KITITAS COUNTY

MEMORANDUM

SUBJECT: Ben Davidson 4 Lot Short Plat

KITTITAS COUNTY SHORT PLAT 07-111

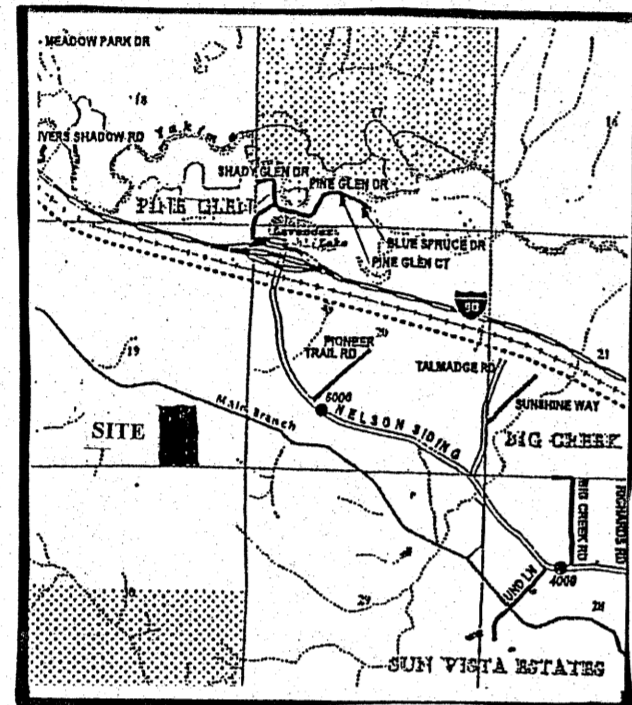
- a. Adjacent Property Owners: The adjacent property owners and surrounding properties shall be on the face of the final short plat. (K.C.C.16.20.040, 10, Plat drawing, Adjacent Owners).

- b. Adjacent Property Lines: The adjacent property owners property lines shall be shown as lighter dashed lines on the face of the preliminary plat. (K.C.C.16.20.040, 10, Plat drawing, Adjacent Owners).

- a. Entire private road shall achieve 95% compaction and shall be inspected and certified by a licensed engineer in the State of Washington specifying that the road meets current Kittitas County Road Standards prior to the issuance of building permit for this plat.

- b. Kittitas County will not accept private roads for maintenance as public streets or roads until such streets or roads are brought into conformance with current County Road Standards. This requirement will include the hard surface paving of any street or road surfaced originally with gravel.

- c. Maintenance of the access is the responsibility of the property owners who benefit from its use.
 - d. An approved access permit will be required from the Department of Public Works prior to creating any new driveway access or performing work within the county road right of way.

- e. Any further subdivision or lots to be served by proposed access may result in further access requirements. See Kittitas County Road Standards.
 - f. A public utility easement 10 feet in width is reserved along all lot lines. The 10 foot easement shall abut the exterior plat boundary and shall be divided 5 feet on each side of interior lot lines. Said easement shall also be used for irrigation.

BEN DAVIDSON REVISED 4 LOT SHORT PLAT

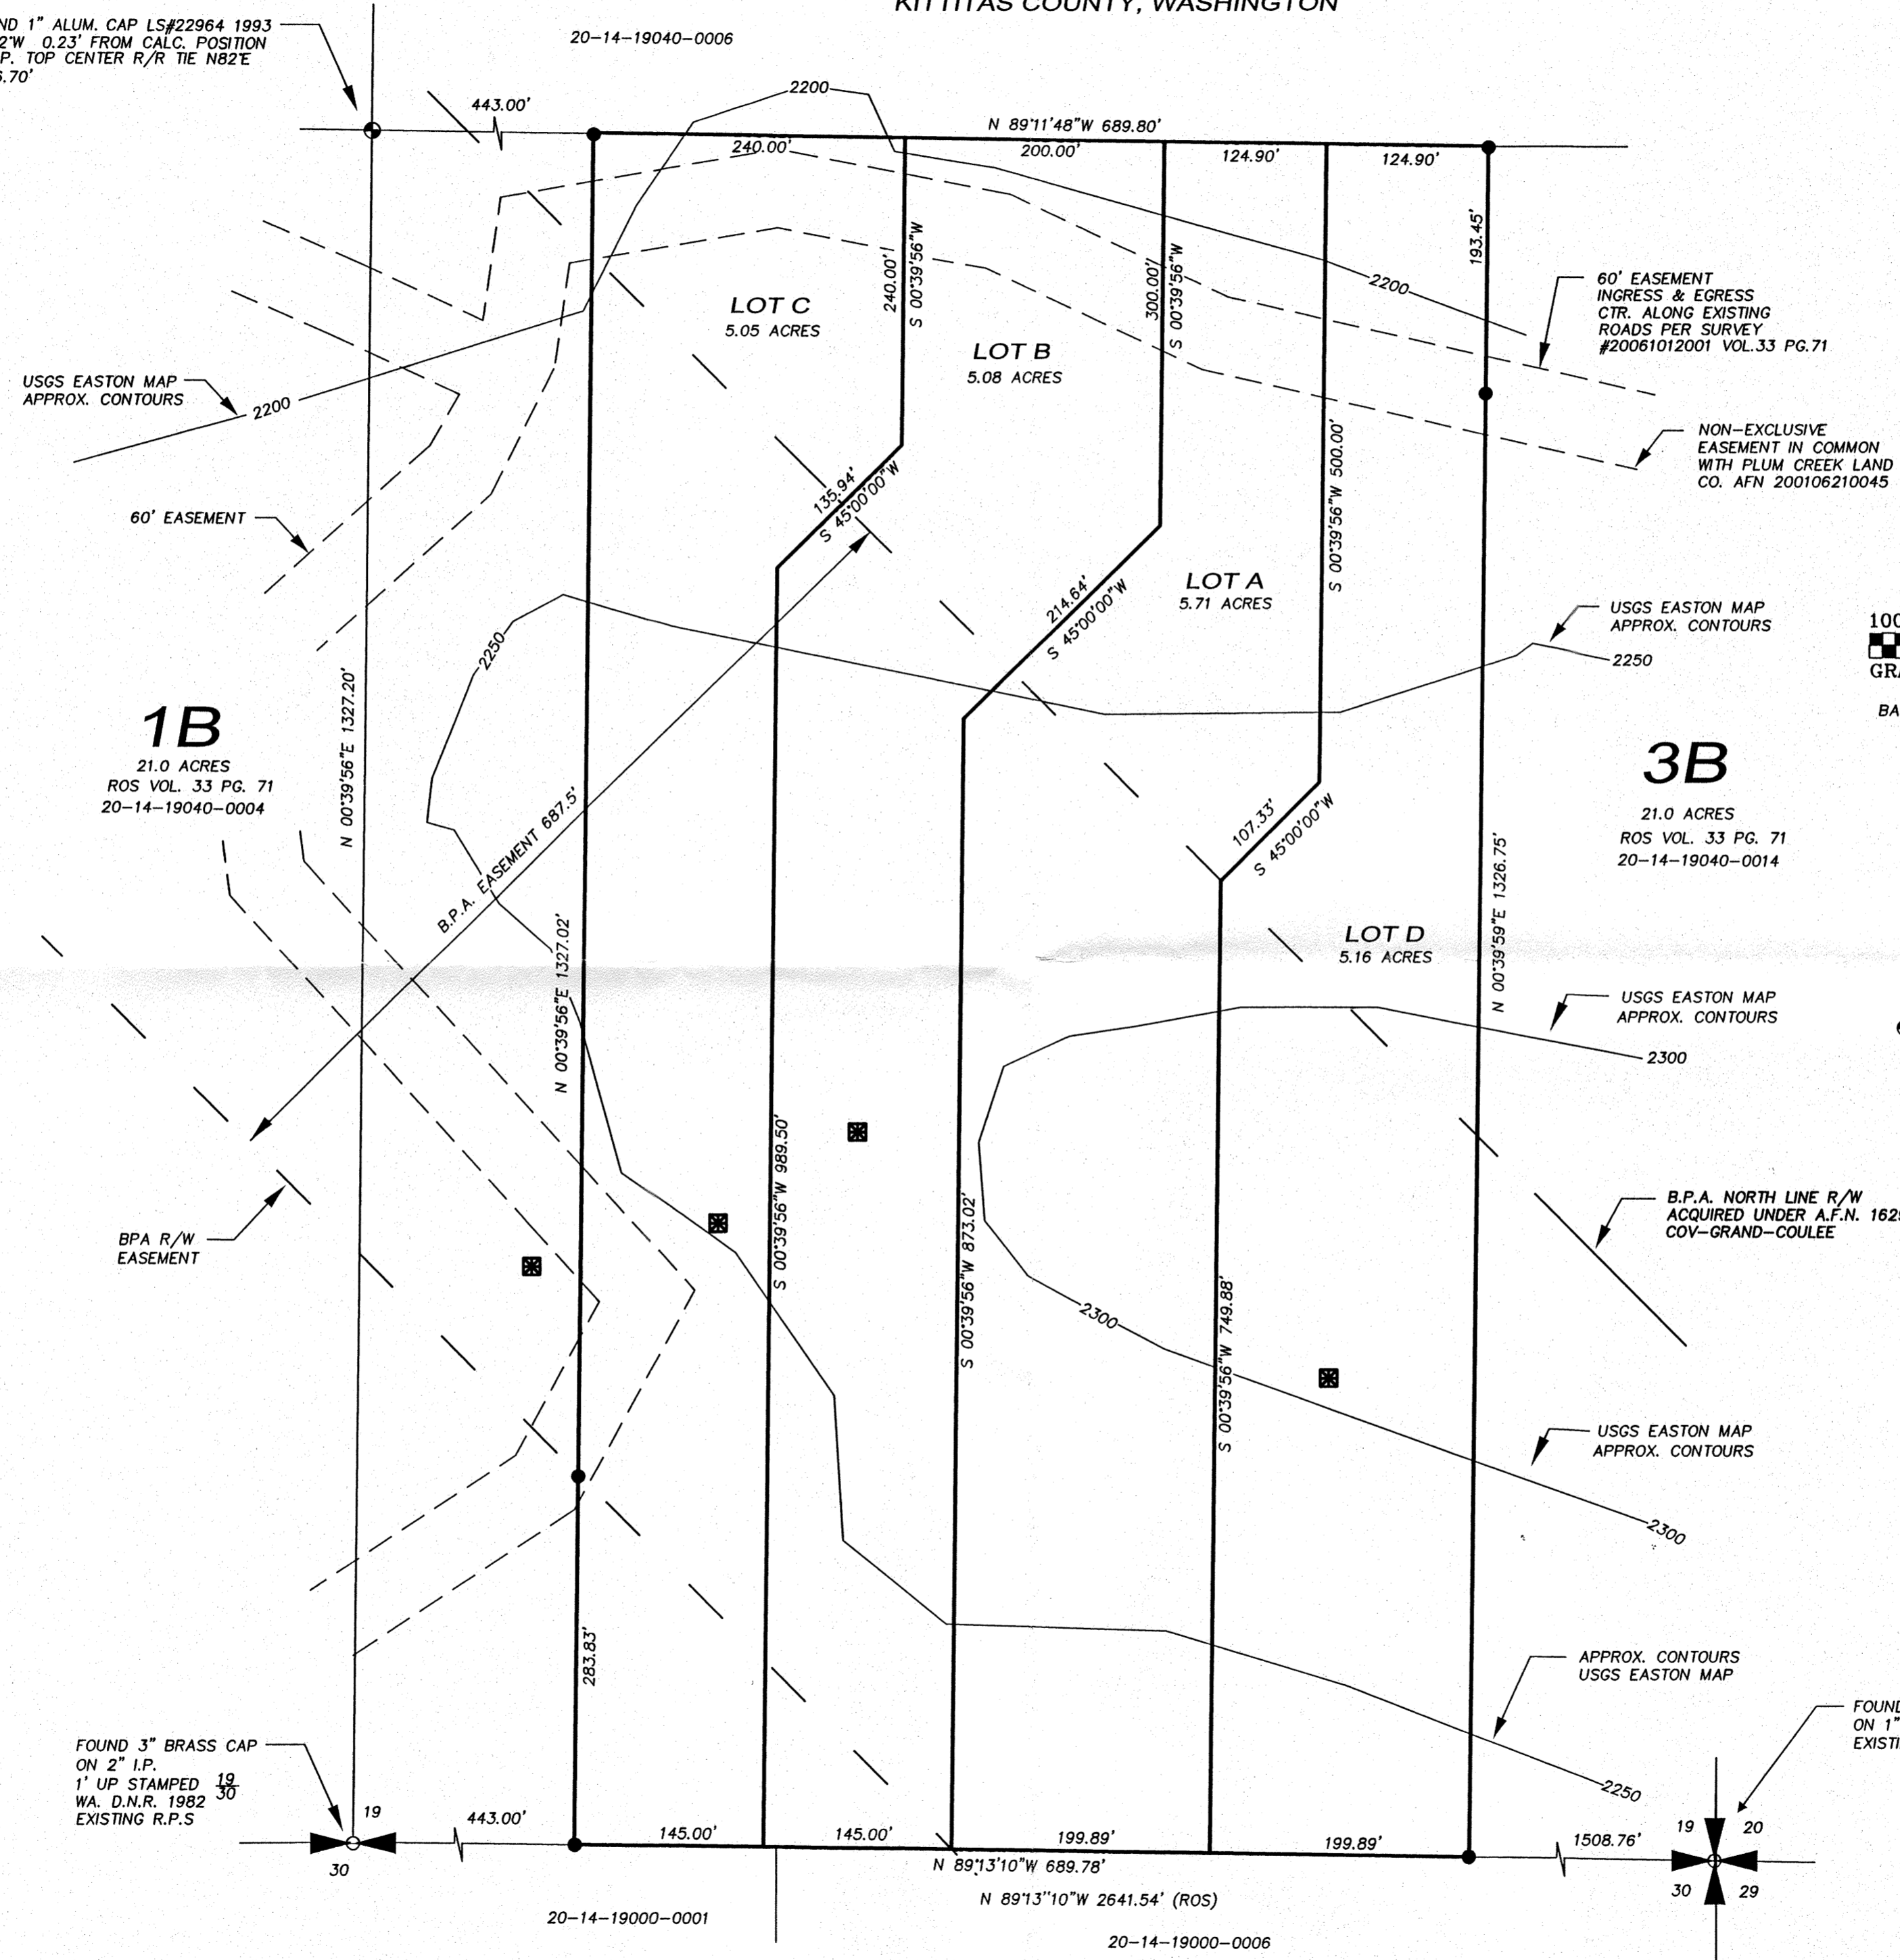
3. Private Road Improvements: Access shall be constructed as a Low-Density Private Road. See Kittitas County Road Standards, 9/6/05 edition.
 - a. Access easements shall be a minimum of 60' wide. The roadway shall have a minimum width of 20', with 1' shoulders, for a total width of 22'.

- b. Minimum centerline radius will be 60'.
 - c. The surface requirement is for a minimum gravel surface depth of 6".

- d. Maximum grade is 12%.
 - e. Stopping site distance, reference AASHTO.
 - f. Entering site distance, reference AASHTO.
 - g. Maintenance of driveway approaches shall be the responsibility of the owner whose property they serve. The County will not maintain accesses.

- j. All easements shall provide for AASHTO radius at the intersection of county road.
 - k. A paved apron shall be constructed at the intersection of the proposed private intersection and the county road right of way.
